**Consultation Response from KC,
Highways Development Management**

2025/91844 Foxhall Environmental Services Ltd, Owler Lane, Birstall, WF17 9BW

Redevelopment of site to include erection of 3 light industrial units, prefabricated offices and waste transfer station shed and open storage

Date Responded: 29-9-2025.

Plan No.
FOX/BIR/IND/PL/03

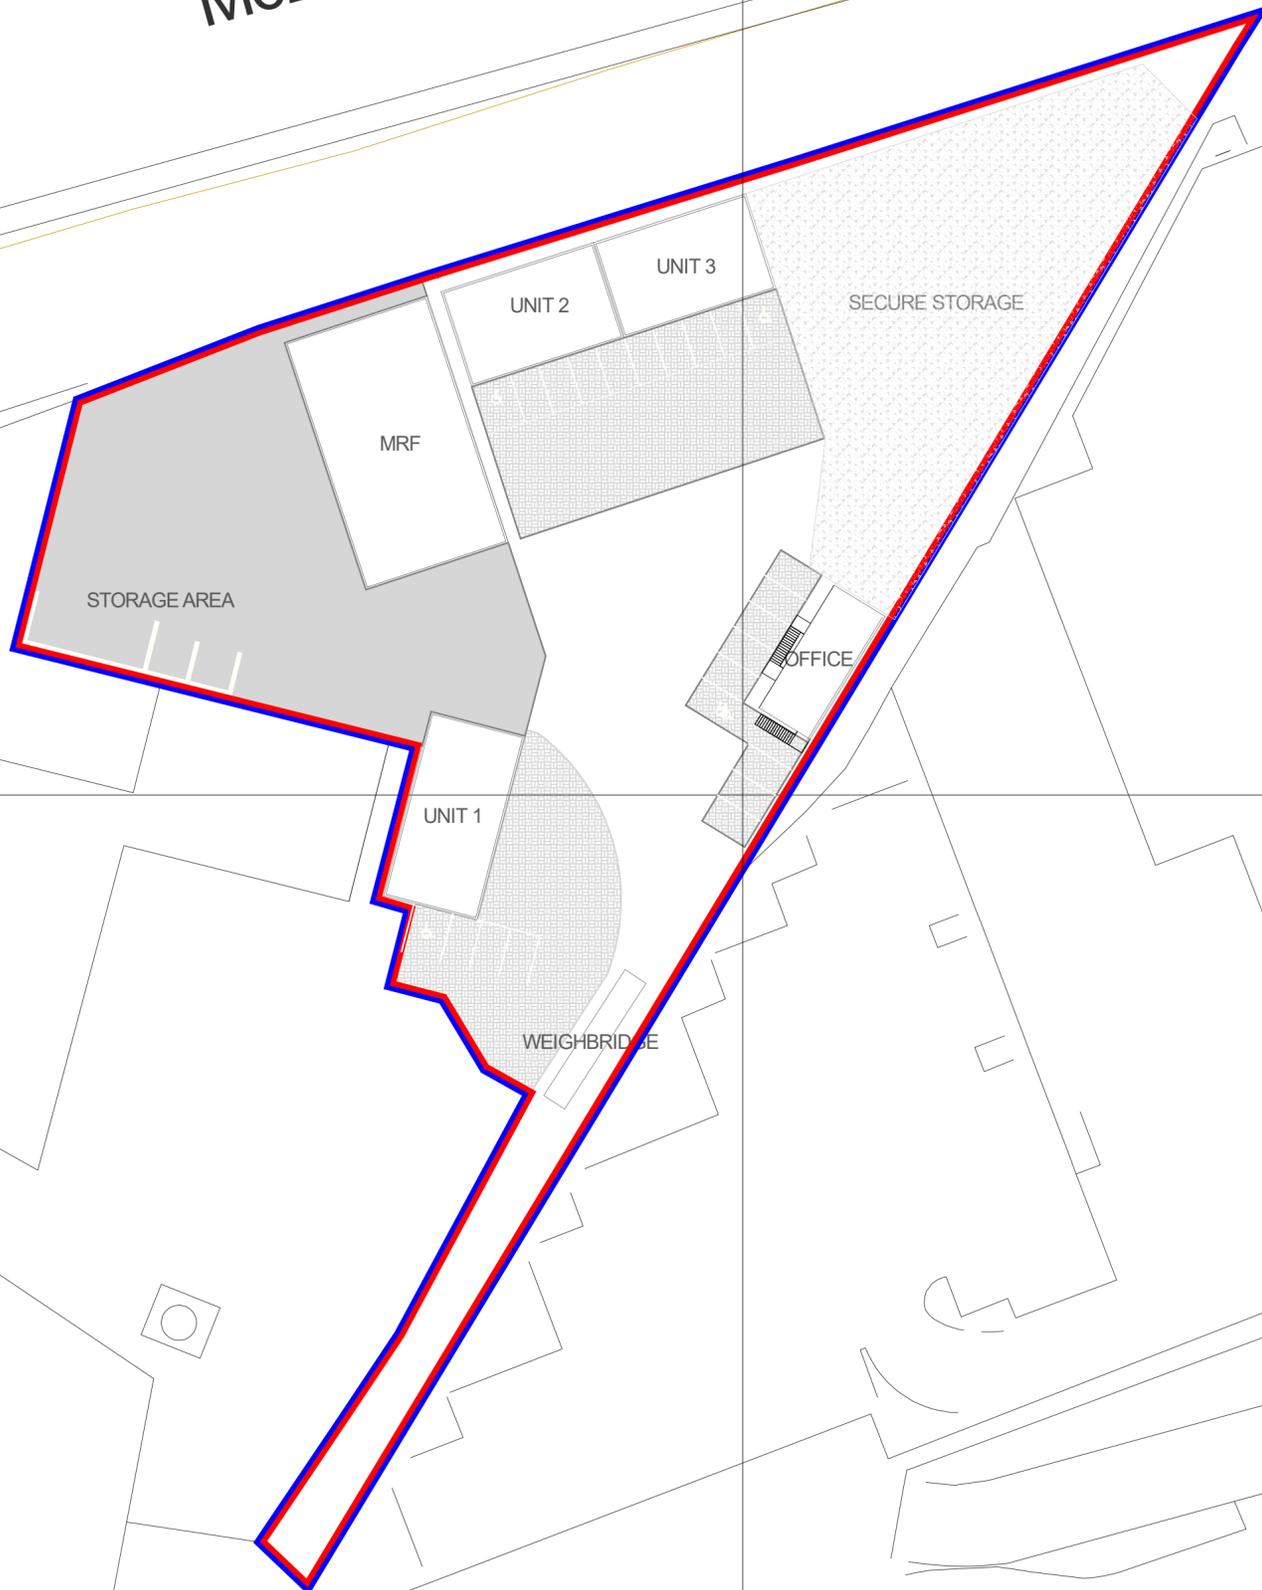
There is an option to provide secure storage within part of the redevelopment of the site. This is not included in the assessment of traffic generation.
